Subdivision Comments

To: Jeremiah Cromie, CDS Planner 2
From: Jesse Cox, Environmental Health Supervisor
Kim Shilley, Public Health Technician
Date: 1/18/2023
RE: SP-22-00005 Johnson-Duvall

JOHNSON-DUVALL SHORT PLAT
 PART OF SECTION 25, T. 18 N., R. 18 E., W.M.
 KITTITAS COUNTY, WASHINGTON

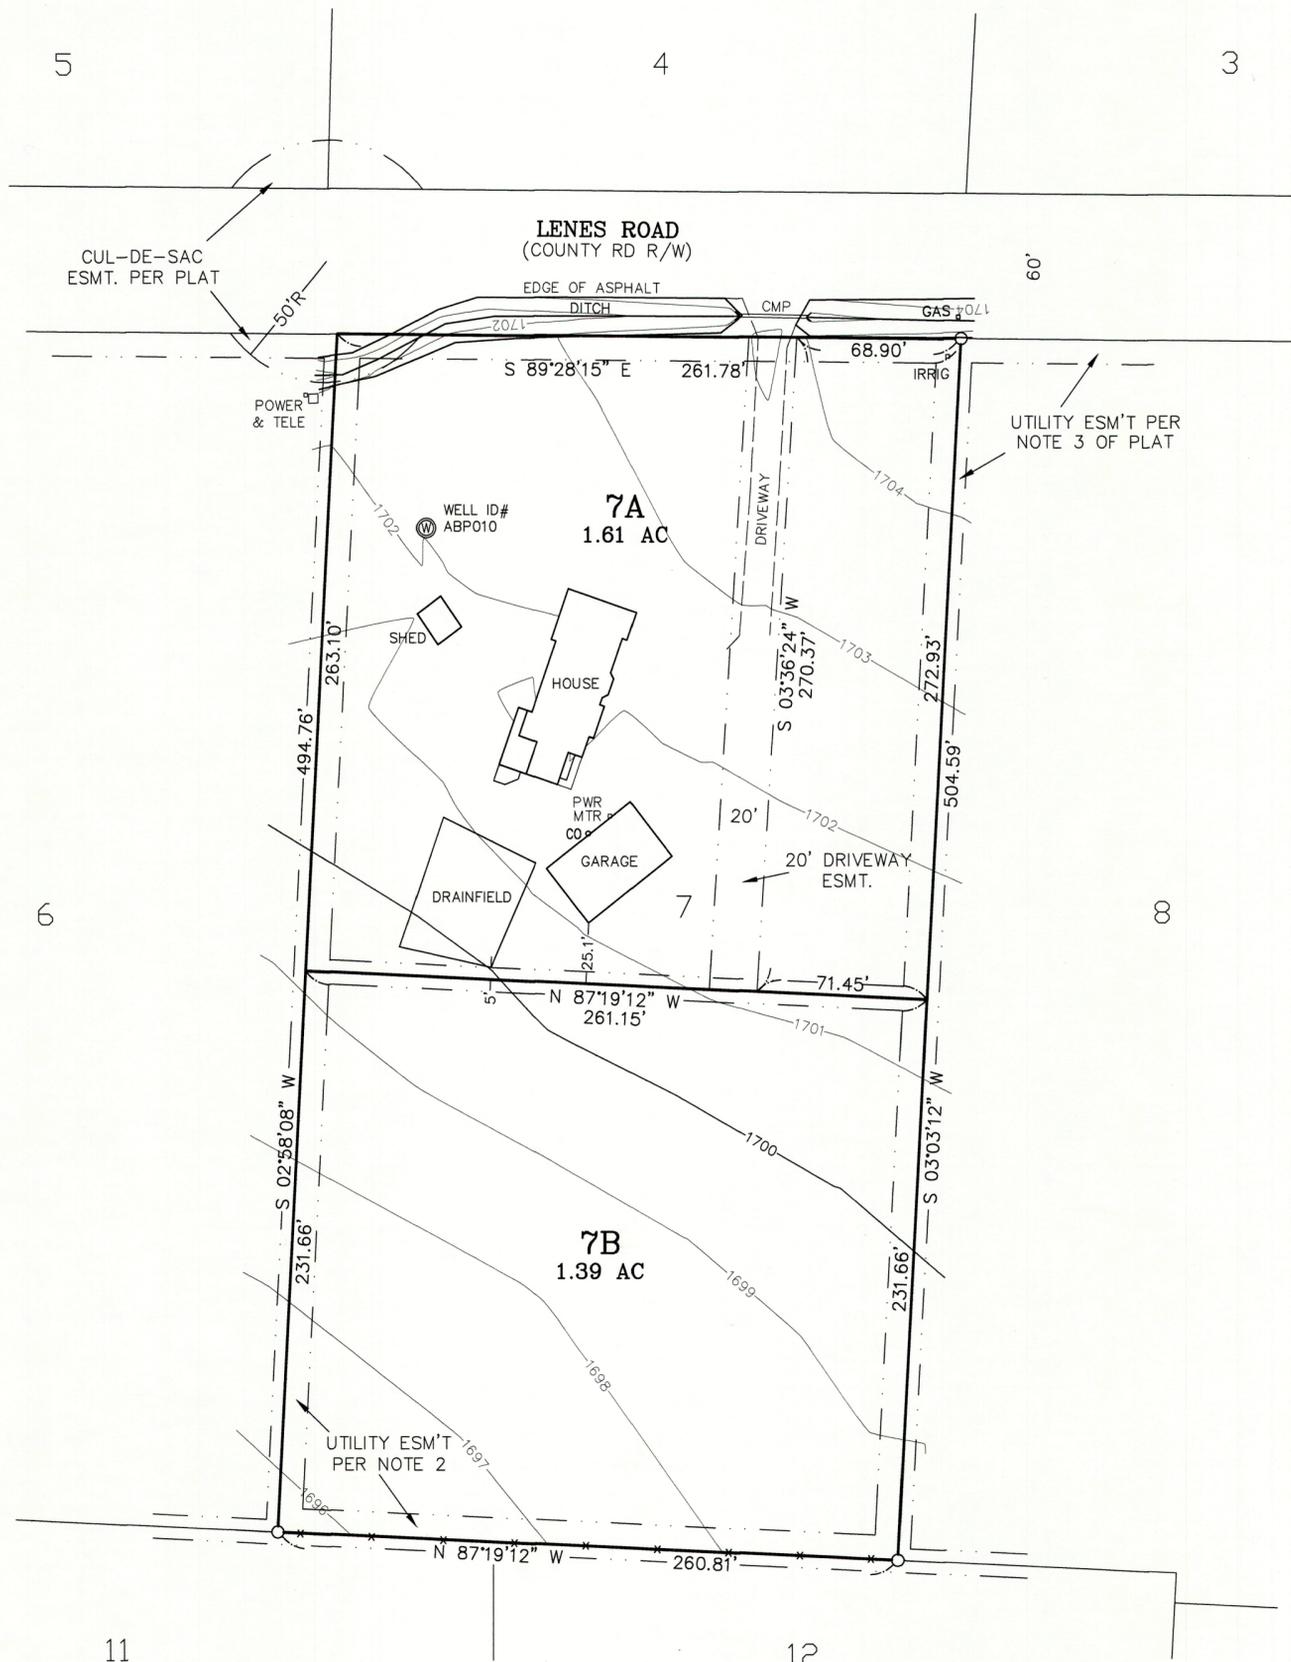
Proposed short plat indicates a shared well will be used. If the intention is to utilize a shared well, a signed, notarized, and filed shared well users agreement will also need to be provided before the short plat is completed. If shared wells are to be utilized, the wells must be drilled a minimum of 50 feet from any proposed property line and a signed, notarized and recorded shared waters users' agreement for each shared well must be submitted to our office prior to final plat approval. The applicant must prove physical availability of water for all new uses of water proposed lots of this project, which can be provided through a well log or 4 hour draw

A soil log is needed for the proposed lots

A signed and recorded shared water user's agreement between proposed lots is needed. Along with a current water right for the proposed lots.
